**New Berrima Brickworks Facility (SSD-10422)
Response to Submissions**

New Berrima Brickworks – SSD 10422

Request for Additional Information

OVERALL FLOOR
PLAN

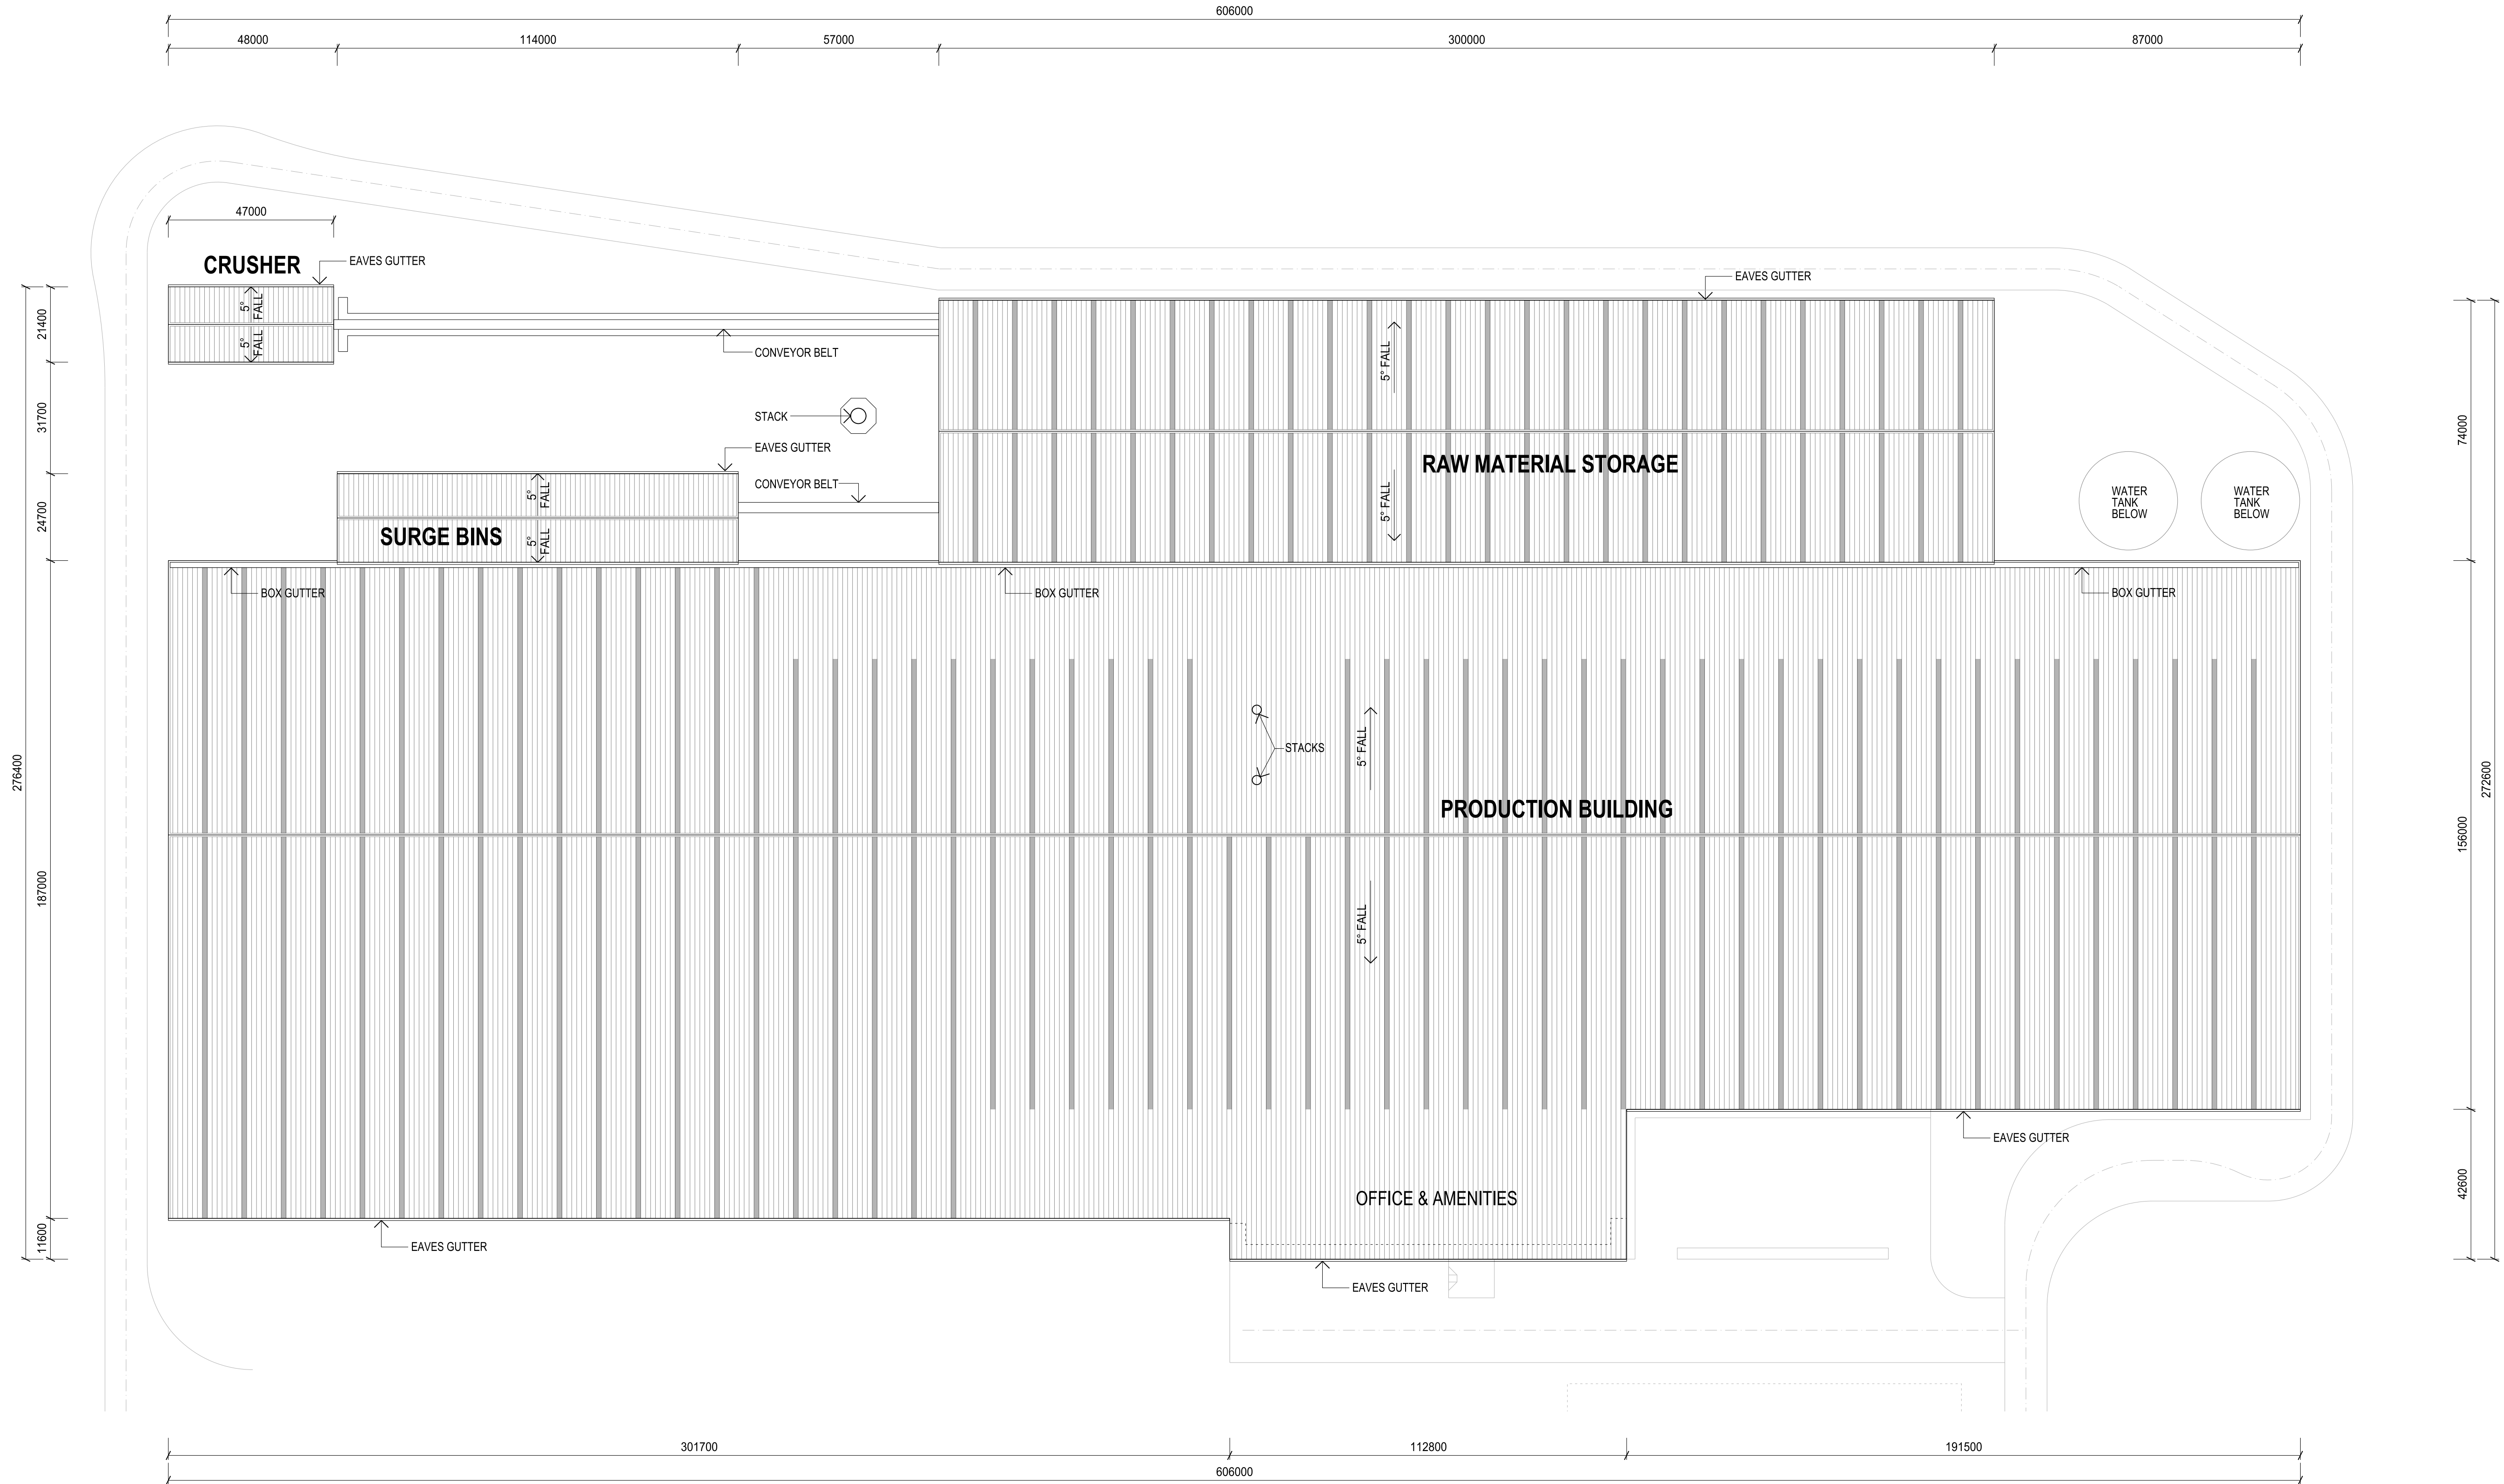
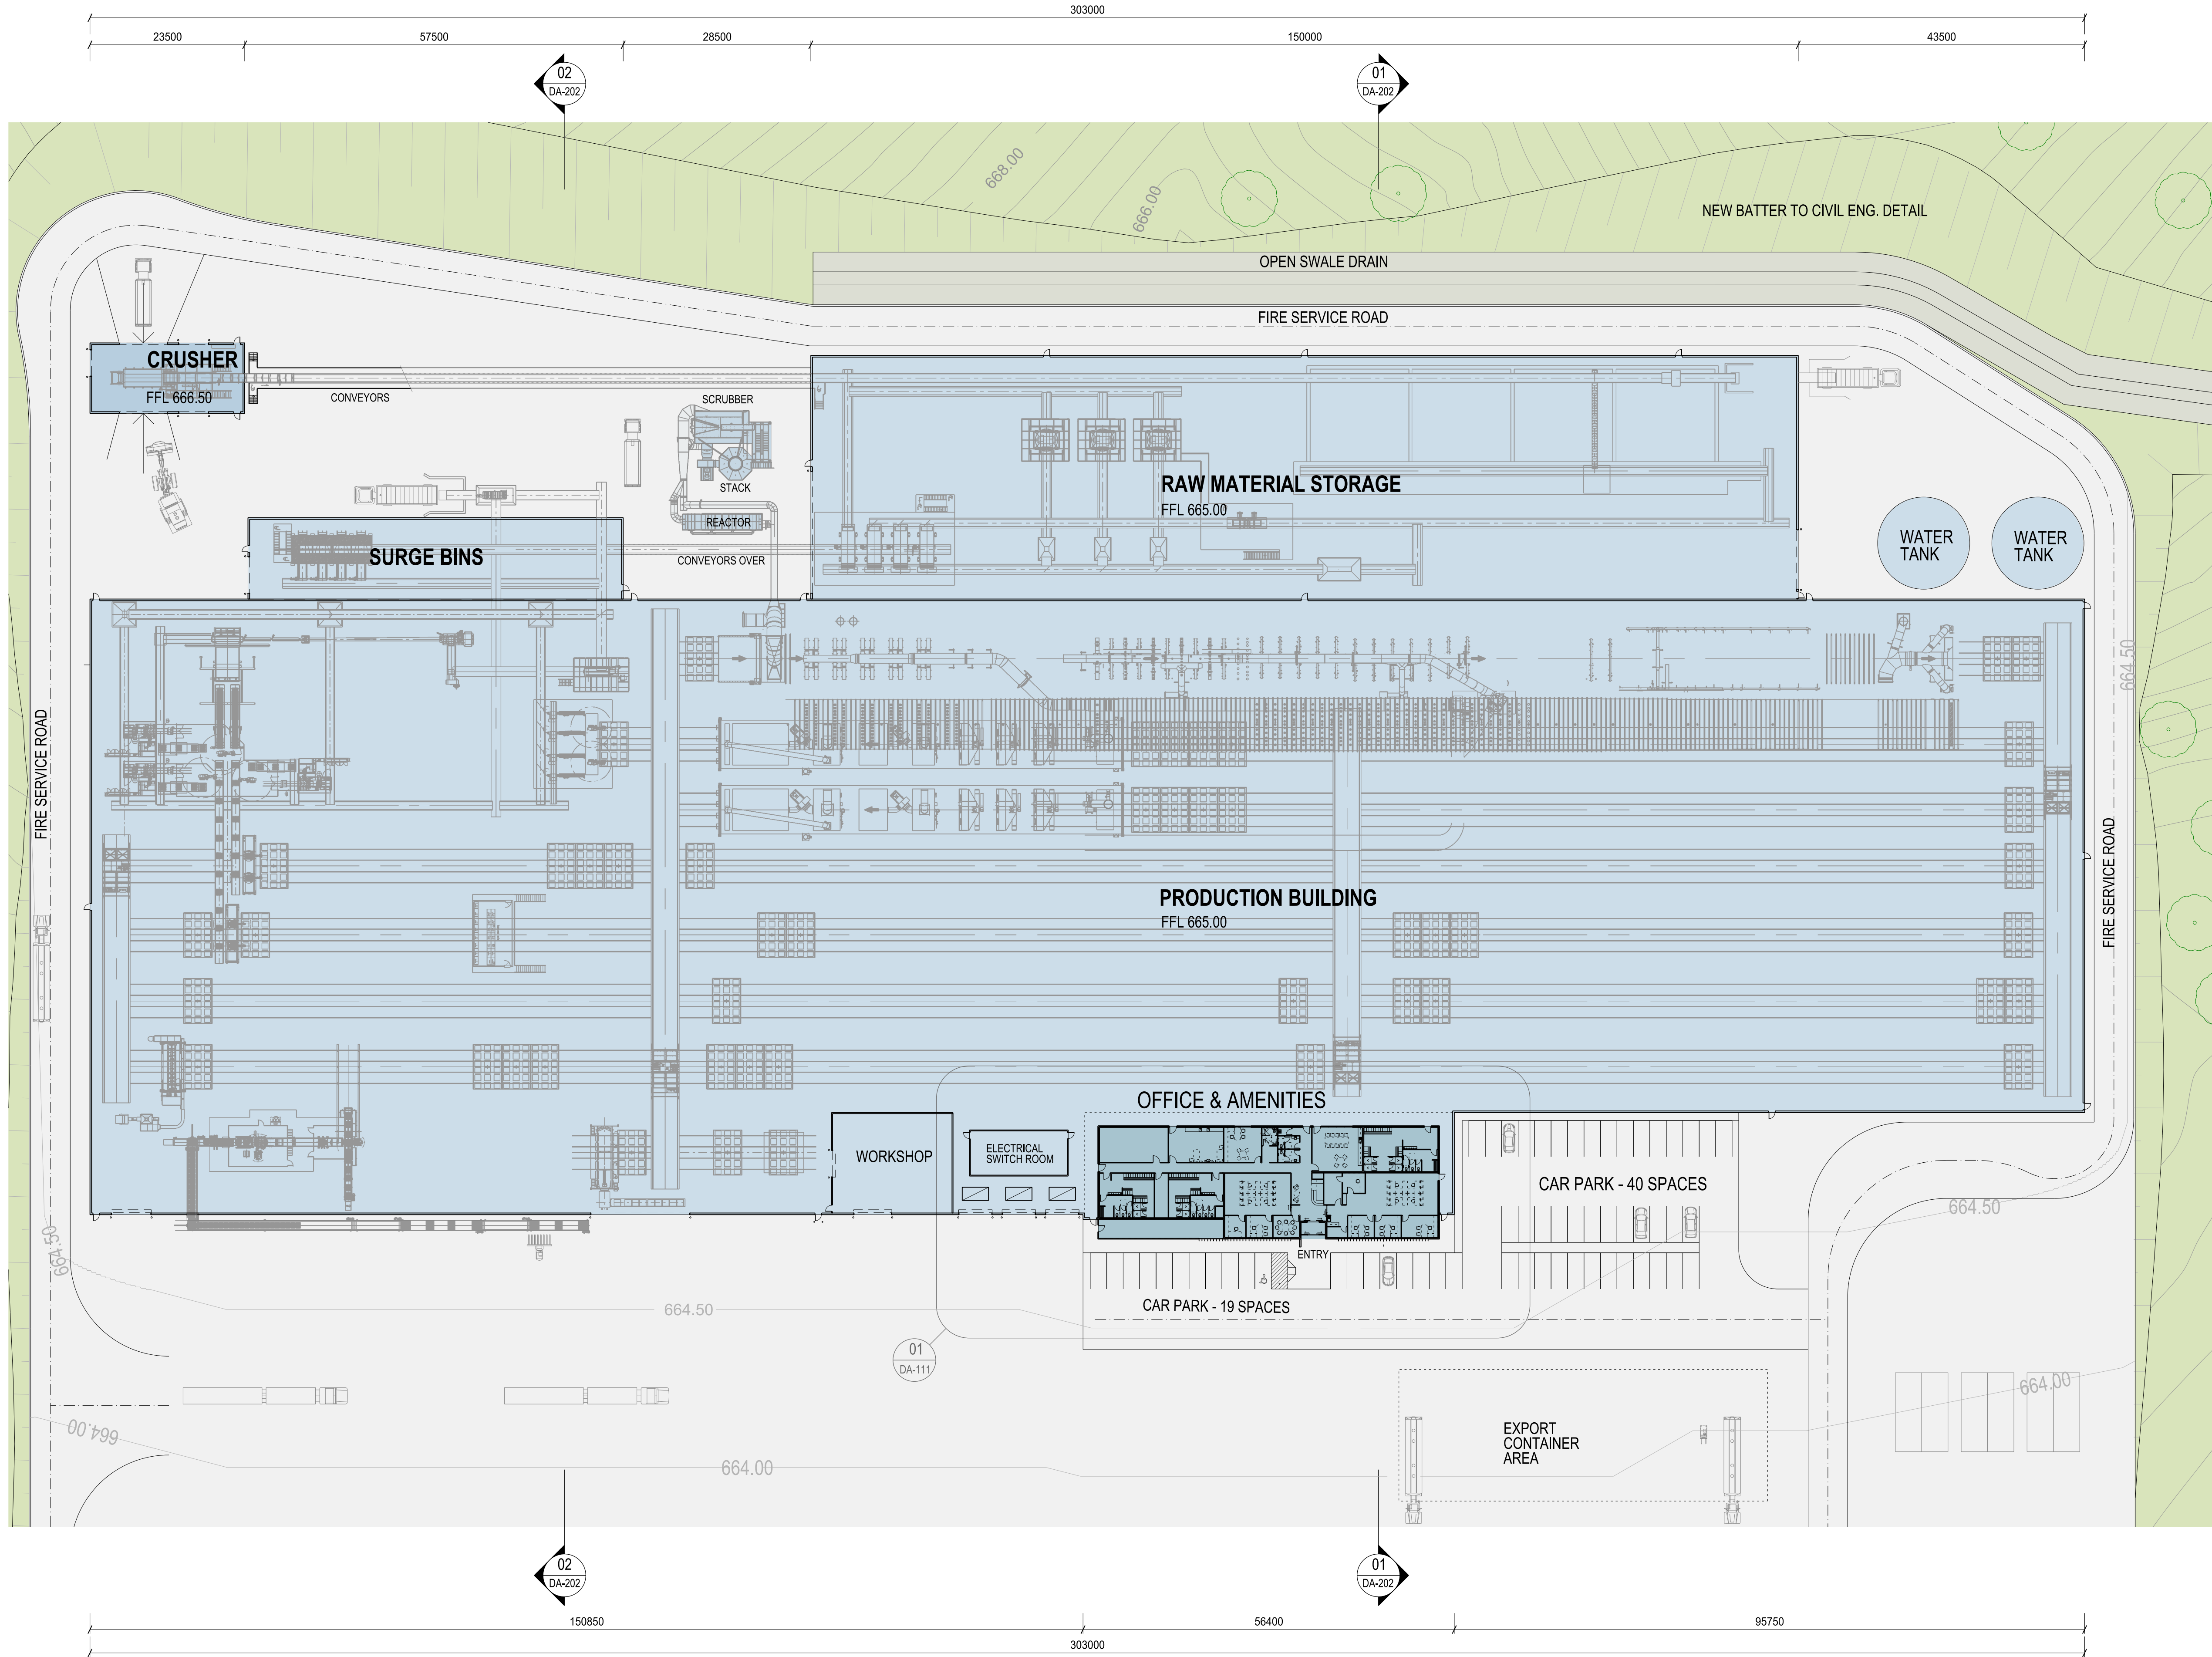
2. The EIS identifies that there are five stages involved in the proposed production process of bricks for the development. However, it is unclear how the five production stages for processing bricks are undertaken on the site. The Department requests an annotated facility floor plan and flow diagram which demonstrates how each production stage is undertaken within the site and the plant and equipment utilised for processing.

8. The EIS does not satisfactorily demonstrate vehicle movements within the development site and the relationship between vehicles and the development. The vehicle movement paths within the site are unclear and not shown in the site plans. It is also unclear how vehicles delivering materials to the site and on-site mobile plant (e.g. front-end loaders) used for processing, manoeuvre through the site and where they are unloaded. The Department requires the Applicant to provide this information to demonstrate access and manoeuvrability of the site is satisfactory for the development’s operations.
